**From:** Anna Russell-Smith <anna.russell-smith@montagu-evans.co.uk>  
**Sent:** 25 August 2021 14:13  
**To:** Richard Phillips  
**Subject:** RE: Northwood & Pinner Cottage Hospital & Northwood Health Centre, Pinner Road - 23658/APP/2021/1296  
**Attachments:** 17115\_05\_PLANNING DRAWING LIST WITH REVs.pdf

**From:** Richard Phillips [<mailto:RPhillips@Hillingdon.Gov.UK>]  
**Sent:** 20 August 2021 14:40  
**To:** Nadine James <[nadine.james@montagu-evans.co.uk](mailto:nadine.james@montagu-evans.co.uk)>; Anna Russell-Smith <[anna.russell-smith@montagu-evans.co.uk](mailto:anna.russell-smith@montagu-evans.co.uk)>  
**Subject:** Northwood & Pinner Cottage Hospital & Northwood Health Centre, Pinner Road - 23658/APP/2021/1296

This proposal is for redevelopment of the former Cottage Hospital along Pinner Road comprising of two plots to include the relocation of the current Northwood Health Centre and two new buildings for 31 one bed units, 34 two-bed units, 5 three bed units, and associated amenities. In assessing this application, reference is made to London Plan policy D5, D7, D12, S4 and T6.1. The following observations are provided:

**Fig 5** Landscape elements plan

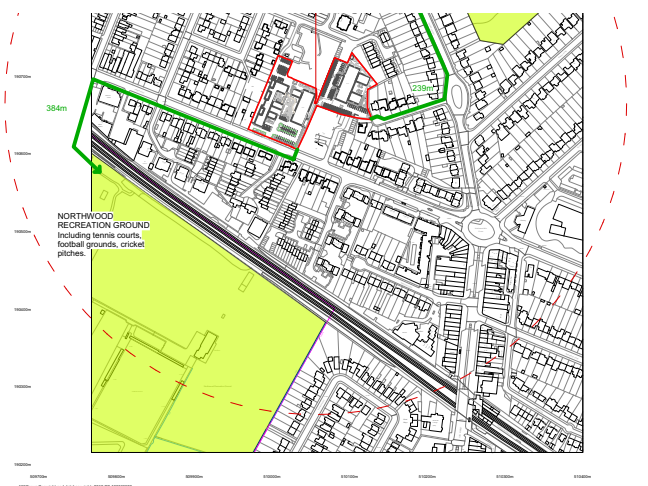
9. Details should be required on the accessible play equipment for disabled children, including those with a sensory impairment, or complex multiple disabilities. Provisions could include outdoor sound tubes, colour and lighting canopies, and other play equipment that could stimulate the olfactory senses. Inclusive play is a key requirement of any new residential development.

Fig 32 1B2P - Cat 3

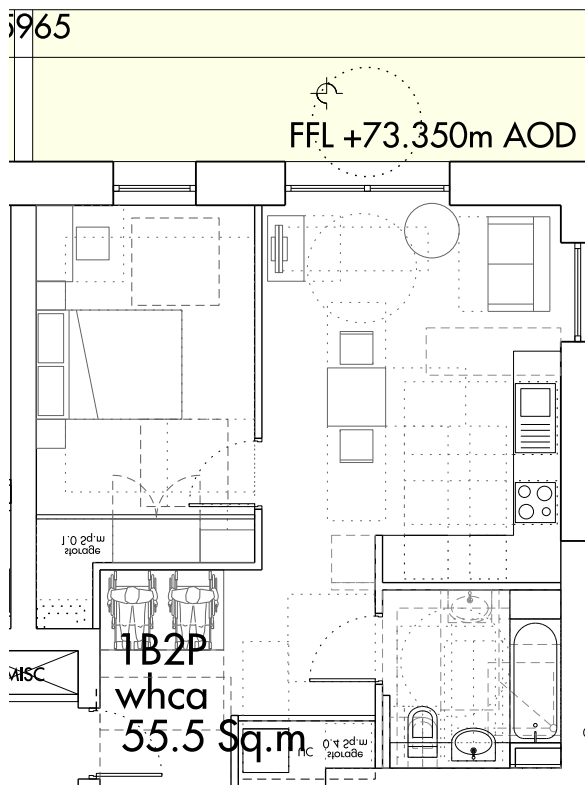
5. The accessible, affordable units should be suitable for 'day one occupation' by a wheelchair user. These units should be designed and fitted as per the prescribed standards for a Wheelchair Accessible M4(3) unit, as set out in ADM 2015. No details appear to have been submitted.

7. A floor plan at no less than 1:100 should be submitted for each of the different M4(3) units. All details, to include transfer zones, wheelchair storage area, and other spatial requirements within bedrooms, bathrooms, living and dining areas, should be shown on a separate plan for every different unit type.
